Tracy Bellamy - Epping to Thornleigh Third track project - SSI 5132

From: Jonathan Ellis <jon.ellis2009@gmail.com>
To: <plan_comment@planning.nsw.gov.au>
Date: 5/11/2012 4:32 PM
Subject: Epping to Thornleigh Third track project - SSI 5132
CC: Janet Ellis <janetellis2006@yahoo.com>, <secretary@2119.org.au>

Figure S.6 Cross-section and elevation - New Cheltenham Station concourse building (see also S.5 for artist's impression)

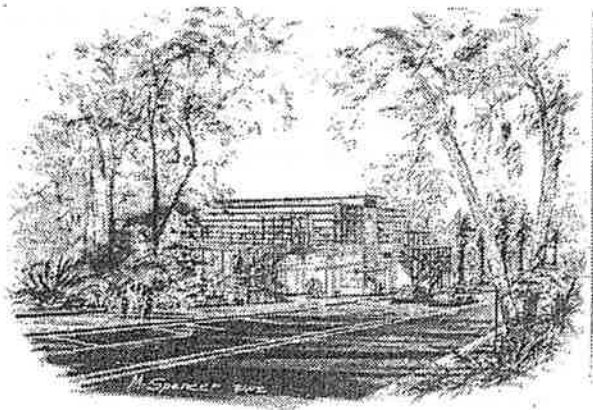
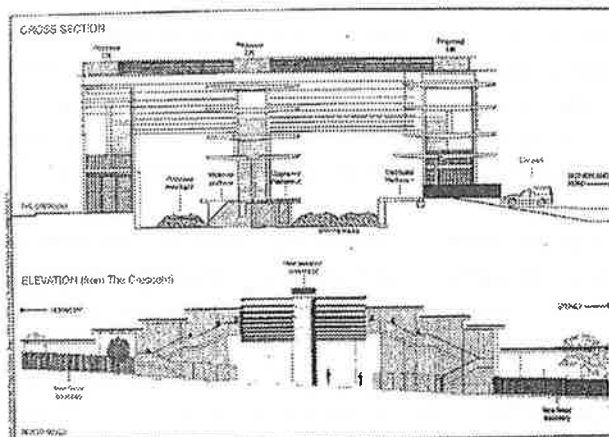
The station design in the EIS looks very much like an off the plan standard station much like those on the Macquarie line. Whilst in themselves they are nice looking in the Cheltenham environment they are completely out of character. We would strongly suggest that a new design more in keeping with the area and perhaps similar to the Pennant Hills Station be considered.
